From: Michael Eastham
Sent: 30 October 2017 14:05
To: Planning.Responses
Subject: FW: BE/102/17/OUT Salt Box, Bersted

I am currently preparing a committee report on the hybrid planning application for the Salt Box site in Bersted and I need the Local Highway Authority's view on the third level of mitigation identified in the Enterprise Bognor Regis Transport Review Report 2017 for the A29/A259 Felpham Relief Road roundabout, which I have highlighted in bold below.

The current planning application is for a new site access to the Salt Box site off the A29/A259 Felpham Relief Road roundabout.

APPENDIX 9.2
SITE ACCESS ARRANGEMENTS

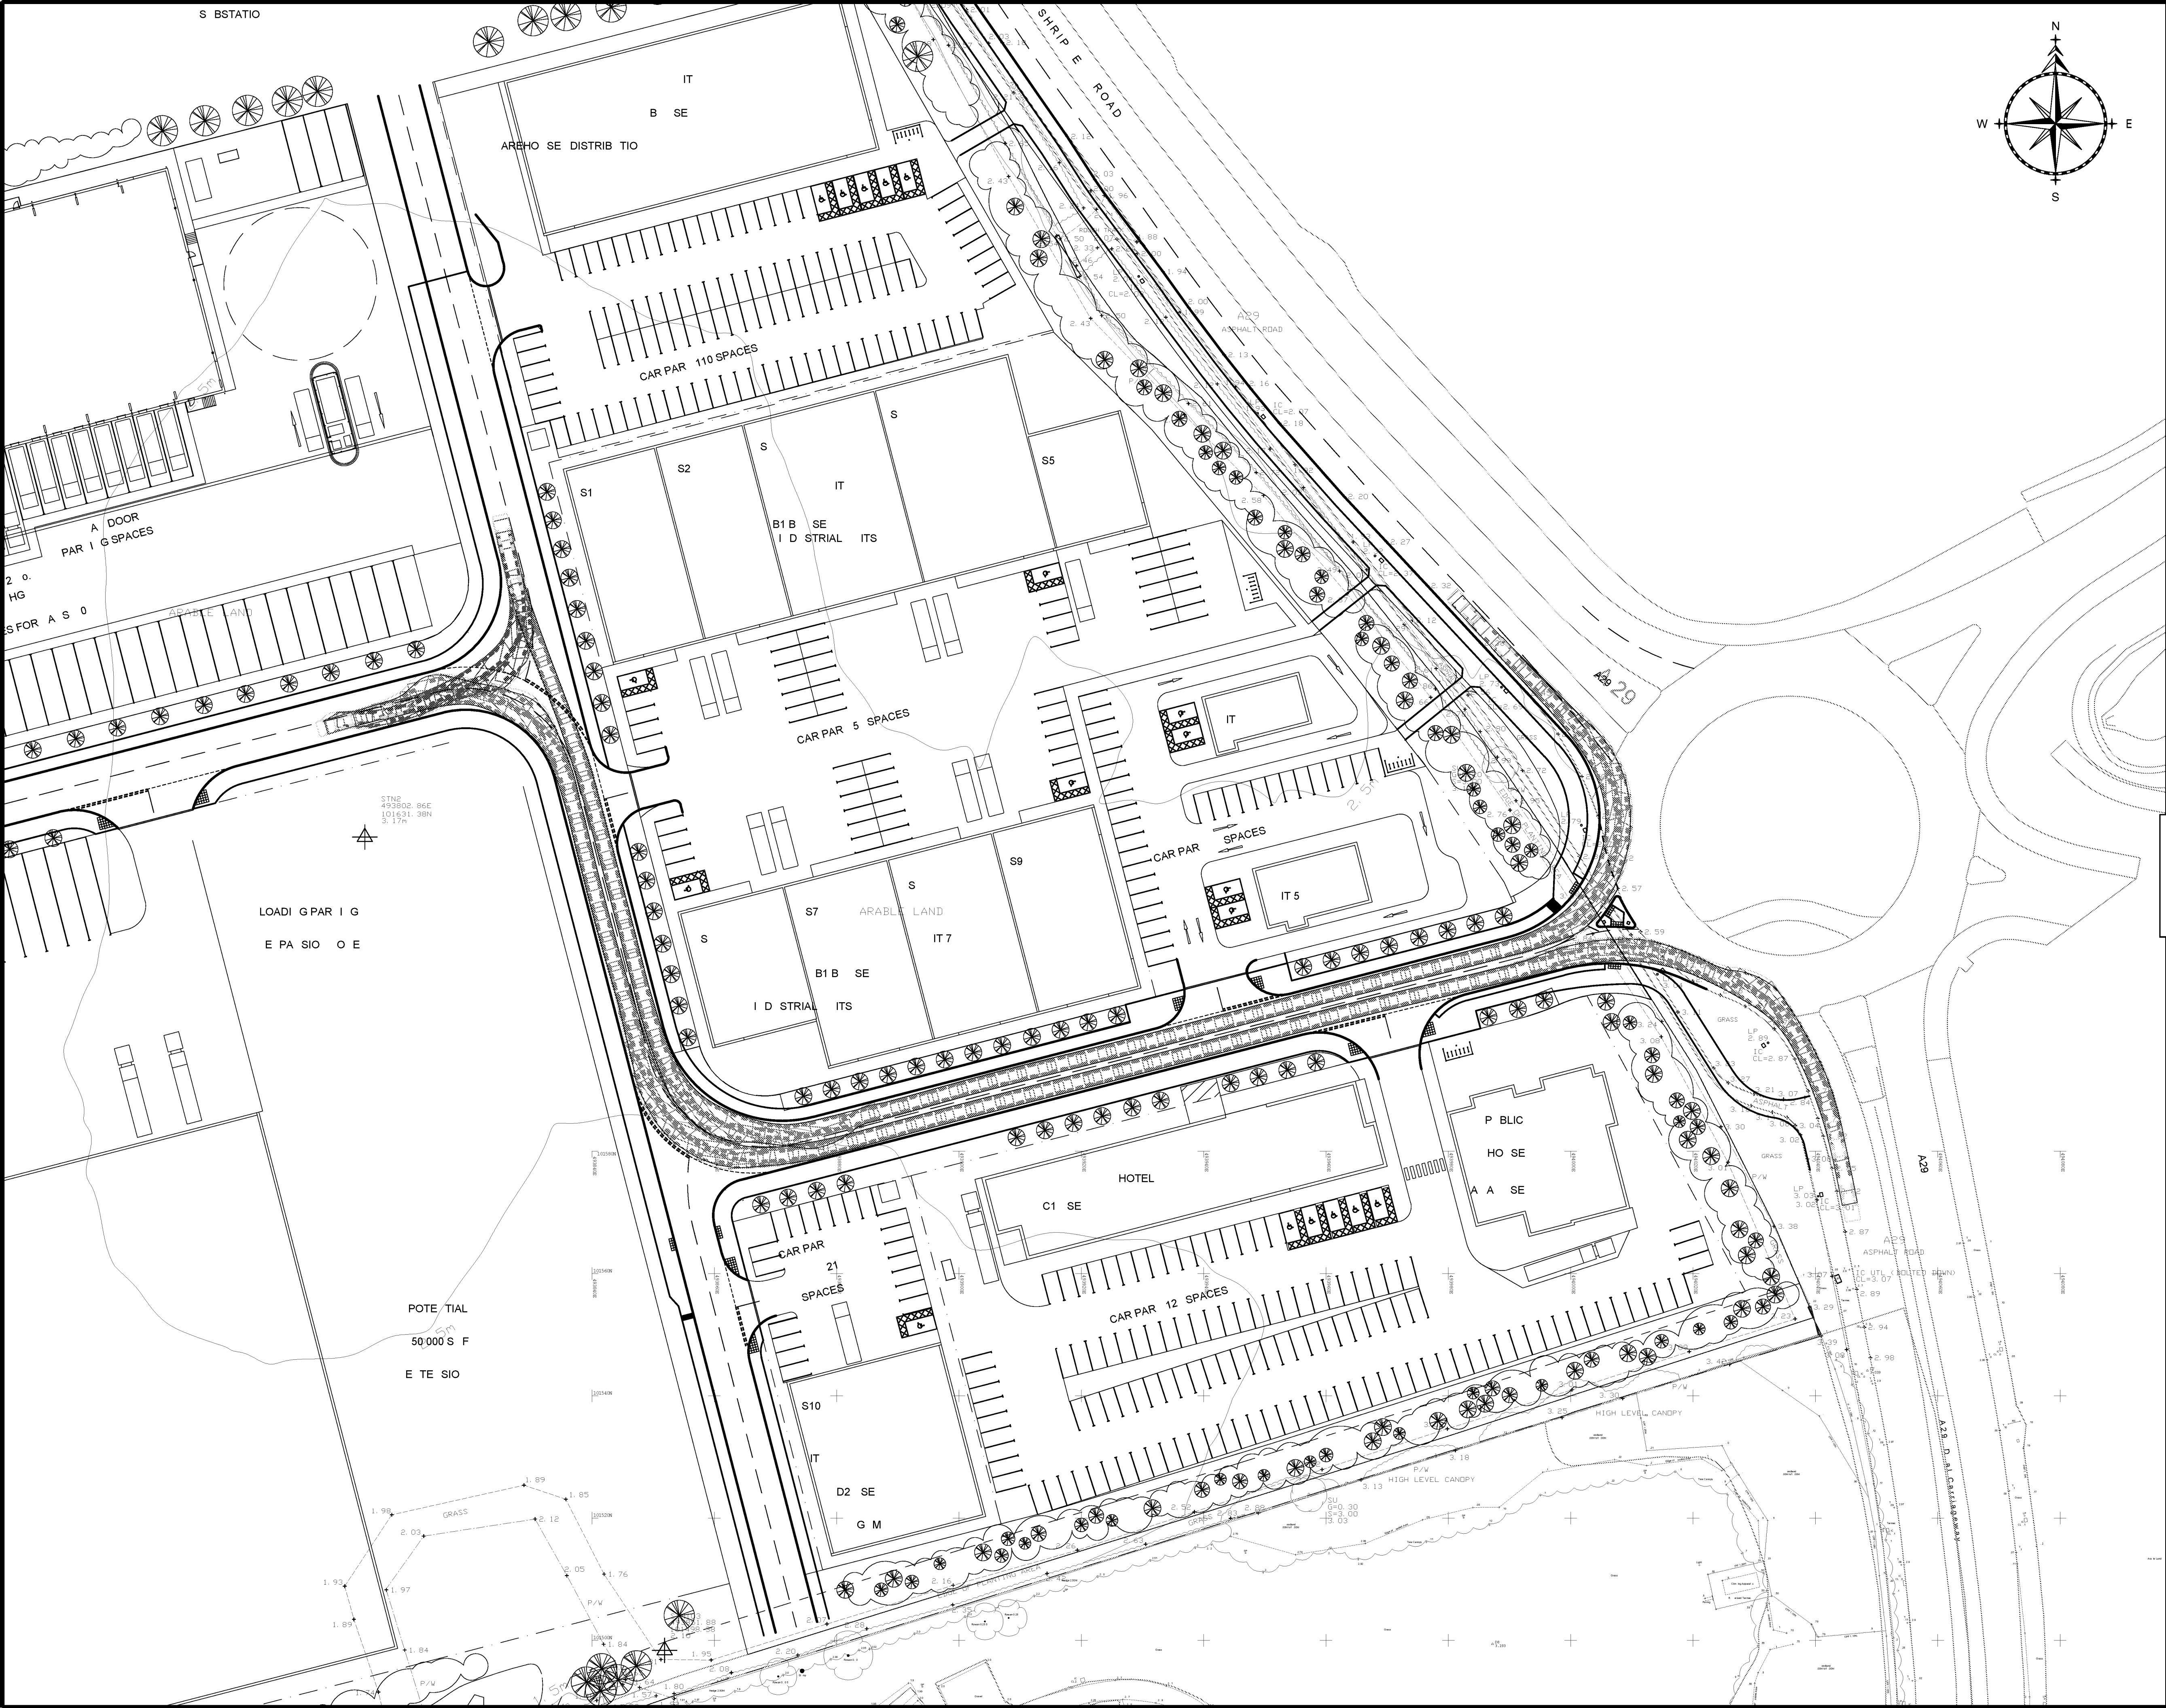
For the purposes of the current planning application, the access arrangements are acceptable. There will though need to be further work to demonstrate that the current planning application does not prejudice the mitigation as suggested within the EBR Transport Review. WSCC will review this work, but it would be for Systra (the authors of the EBR Transport Review) to demonstrate that an alternate access is feasible and for the applicants of the current planning application to demonstrate that their site does not prejudice this.

- **The removal of the Salt Box / Rowan Park access (re-located further north on the A29).**

How should I deal with the current planning application in terms of site access proposals.
